## **Landscape and Visual Impact Assessment & Landscape Matters**

### **Addendum**

**Circular Economy Hub at Huntstown, (to east of Mulhuddart) County Dublin**

**November 2023 / Project No. 7670**

Figure 15 Extract from drawing no. 7670 L2101 annotated to identify specific hedgerow proposals

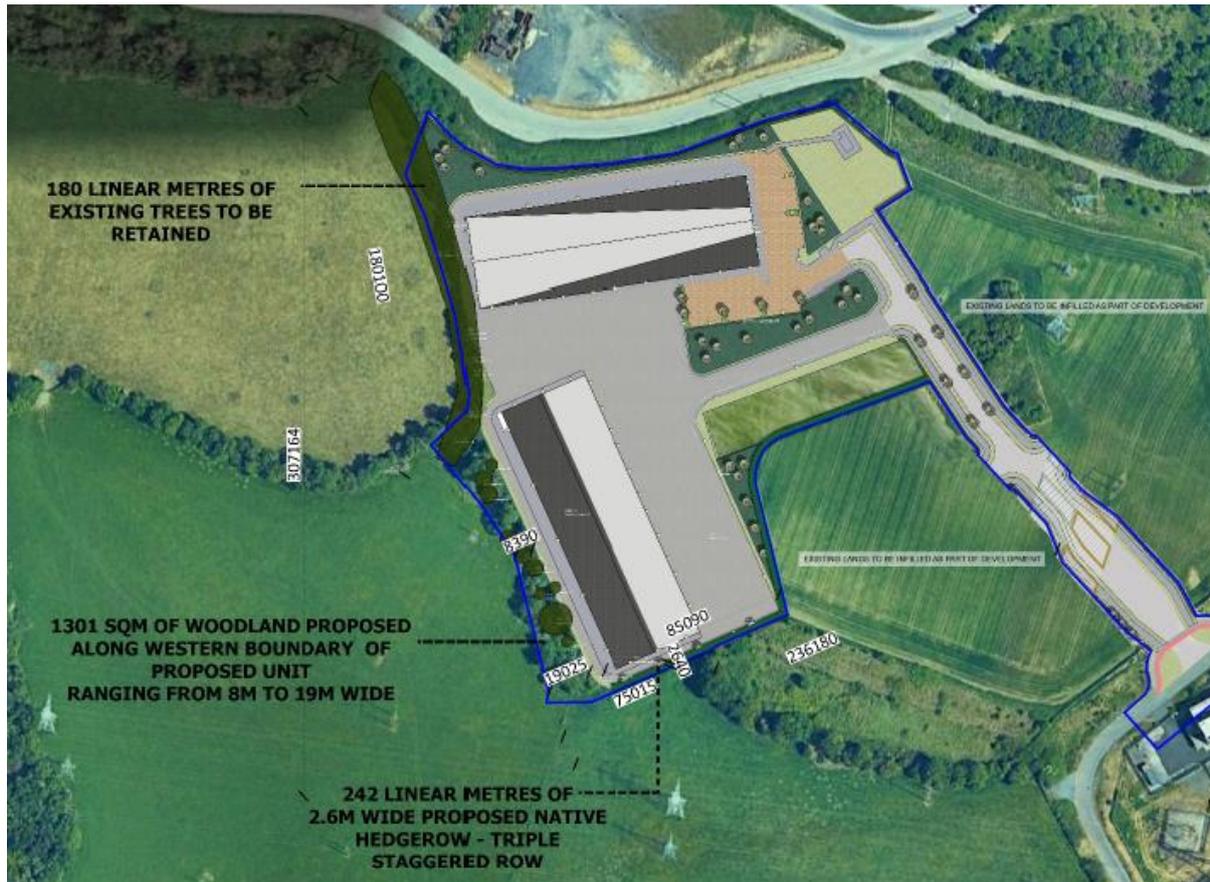
*14F: The documents submitted with the application, including the EIAR, acknowledges the significance of the trees and hedgerows on the western and southern boundary of the site. The documentation states that this boundary will be retained, protected and augmented. This boundary is also a townland boundary/ feature. However, it is considered that the proposed development does not make adequate provision for the protection, retention and augmentation of this significant cultural, ecological and landscape feature either in terms of appropriate setback - stated as being 7 to 10m in the planning and design statement (Section 4.2, Genesis Planning) - or in terms of its full retention. In many places, aspects of the proposed development are significantly closer to the hedgerow and in-part it is proposed to remove a section of the feature entirely. The applicant is requested to revise the layout of the proposed development so as to maintain the stated setback of 7m minimum from any aspect of the proposed development, including fencing, to the edge of the vegetation in the town land boundary. The revised layout shall have regard to the findings, including root protection areas, and any recommendations for retention of trees/ hedgerows of amenity value, in the updated arboricultural survey.*

*14G: The Landscape Masterplan for the site shall be updated to reflect the revised layout (to indicate the appropriate incorporation and augmentation of the townland feature on the western*

- 4.1 Additional site visits were undertaken to review the condition and value of the vegetation on this site boundaries for which – as noted above – the Tree Survey rated the general condition as being of low quality and the amenity value also as low. Irrespective, the hedgerows to the west and south of the site exist forming part of the landscape character and the landscape design objective is to retain and augment their presence. **See Photo 1** below
- 4.2 The layouts have been amended to allow for the retention of the western hedgerow (total length c. 307m) and its augmentation where weak with additional native hedgerow species to gap up these sections. Further, the hedgerows will be given appropriate management to remove ivy, remove dead

material and cut back the hedge faces to return them to a more compact form in line with their original intent. On the inside (or within Application Site), native woodland belts will be planted that will further augment the boundary vegetation in this area as it matures. The minimum depth of any boundary vegetation will be 7m and, in sections, the existing hedge and proposed woodland belt will be of up to 16m wide. The area of proposed woodland plant equates to 1,300m<sup>2</sup> in total.

- 4.4 Immediately to the south of the proposed Warehouse B is a section of hedgerow equating to approximately 75m. This includes 4 no. Ash (*Fraxinus excelsior*) trees surveyed as T007, T008, T009 and T010 for which the Tree Survey has recommended felling on the basis that they do “... *not merit retention due to disease*”. In and around the trees is a collective of “*single and multi-stemmed trees*” that were assessed as part of a group, T030. Again the Tree Survey has recommended their felling due to disease. It is therefore proposed that this collective diseased vegetation is removed and that the area between the proposed hardstanding associated with proposed Warehouse B and the

boundary is (re)planted with a replacement hedgerow. It is acknowledged that this area is thinner than the western boundary but, at 2.6m wide, there is sufficient room to provide an appropriate hedge made up of mixed native species. In total, based on a triple staggered row, this section would equate to 450 no. plants which, on maturing, would provide an improved buffer and screen over what is currently offered by the existing hedge.
